Tel: 01903 737756  
Email: [planning@arun.gov.uk](mailto:planning@arun.gov.uk)  
[www.arun.gov.uk/planning](http://www.arun.gov.uk/planning)  
Please ask for: Amy Anderson  
Email: [amy.anderson@terraquest.co.uk](mailto:amy.anderson@terraquest.co.uk)  
Telephone: 0121 234 1390  
Our Ref: M/87/25/HH  
Your Ref:  
Date: 11th November 2025

**Application for Planning Permission for Works or Extension to a Dwelling**

**Development:** Single storey side/rear extension and alterations to fenestration, following demolition of existing garage.  
**Location:** 2 Shrubbs Drive Middleton-On-Sea PO22 7SQ

PROPOSED ELEVATIONS

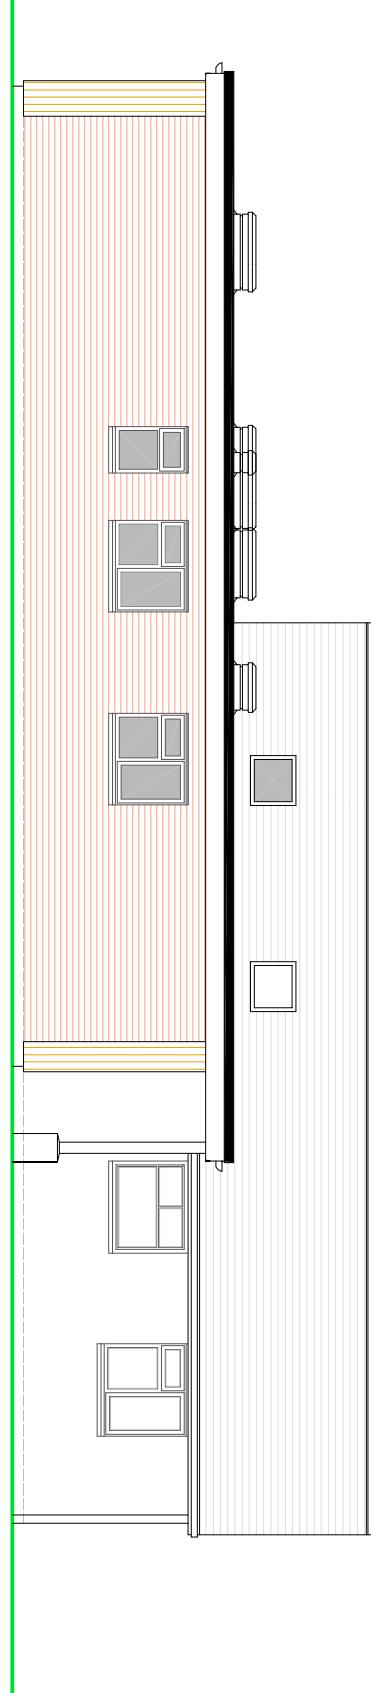
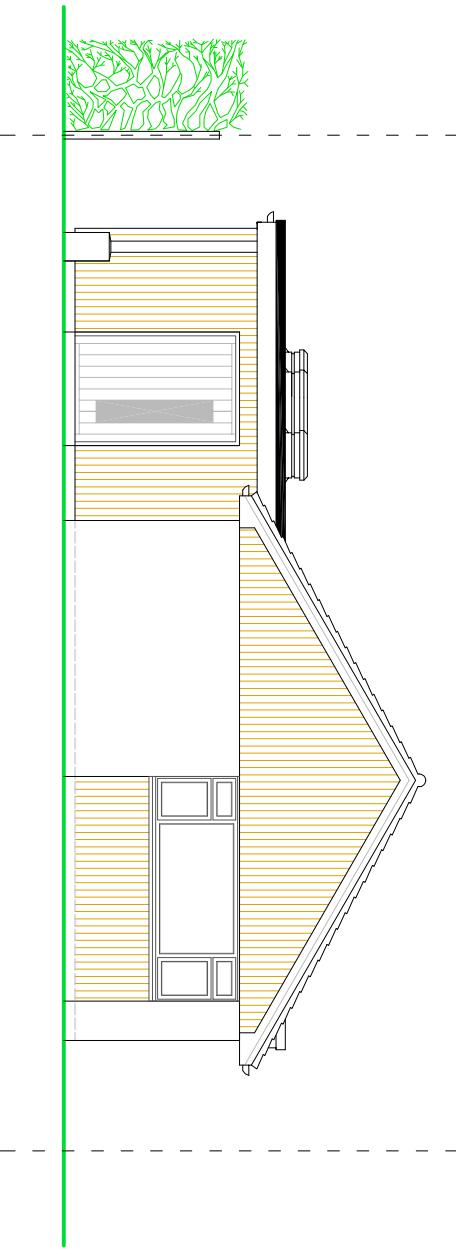
The roof lights on the extension are inconsistent across elevations/plans. Please review and amend accordingly.
